MEMORANDUM

Subject: Application ID: 2008-0185

**COVERED GARAGE/STORAGE
84-88 OAK ST.**

**REQUEST TO EXCEED MAXIMUM SETBACKS IN SECTION 14-220(C) DIMENSIONAL
REQUIREMENTS OF DIVISION 12 B-3, B-3b AND B-3c DOWNTOWN BUSINESS ZONE
TOM MOULTON, APPLICANT**

A1	Date: 19 December 2008	Scale: 1/8" = 1'-0"	Revisions:	PROJECT: Garage	ARCHETYPE, P.A. ARCHITECTS 48 Union Wharf Portland, Maine 04101 (207) 772-6022 Fax (207) 772-4056	OWNER: Tom Moulton
	SITE PLAN			84-88 Oak Street Portland Maine		547 A Congress St, 6th Floor Portland, Maine 04101

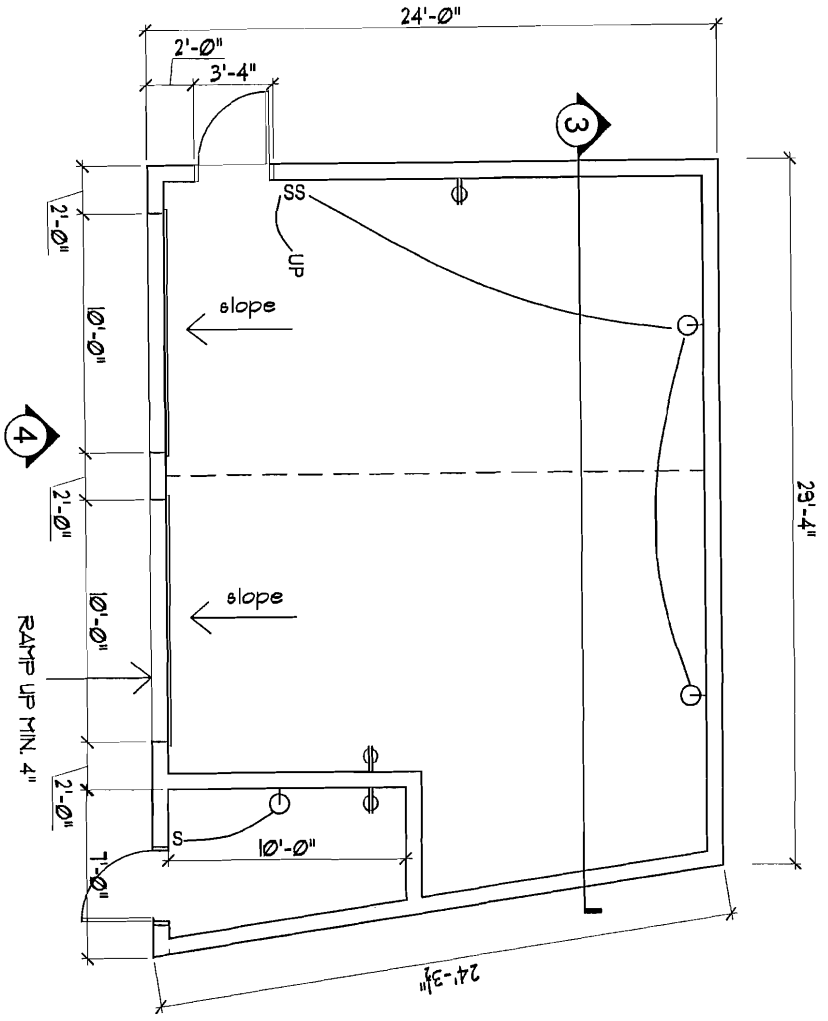
This property is located in a B-3 Downtown Business Zone. It is an existing parking lot. The applicant is proposing to take three of the rear parking spaces and enclose them with a structure for two parking spaces, a storage loft and a separate room for a use that was not given in the application. I would like a little more information on the extra room (what use?).

The scaled height of the building is 16'. This structure does not need to meet the minimum height requirement of 35' as outlined in two exemptions. The structure is over 50' back from the street line and 14-220(h) exempts "covered parking".

Section 14-220(b)(5) states that even a minor site plan review for "surface parking" requires a conditional use appeal approval from the Planning Board. I would suggest that this proposal does not fall under the description of "surface parking". The existing parking is proposed to be enclosed with a structure and would not then be considered "surface parking". Therefore I would contend that this proposal would not need a conditional use approval from the Planning Board under this section.

Section 14-220(c) "Streetwall build-to line" : A building or structure shall be located within 5' of the property street line unless the Planning Board approves the additional distance to comply with the site plan requirements of 14-526(a)(16). The proposed structure is located well beyond the 5' streetwall build-to line requirements.
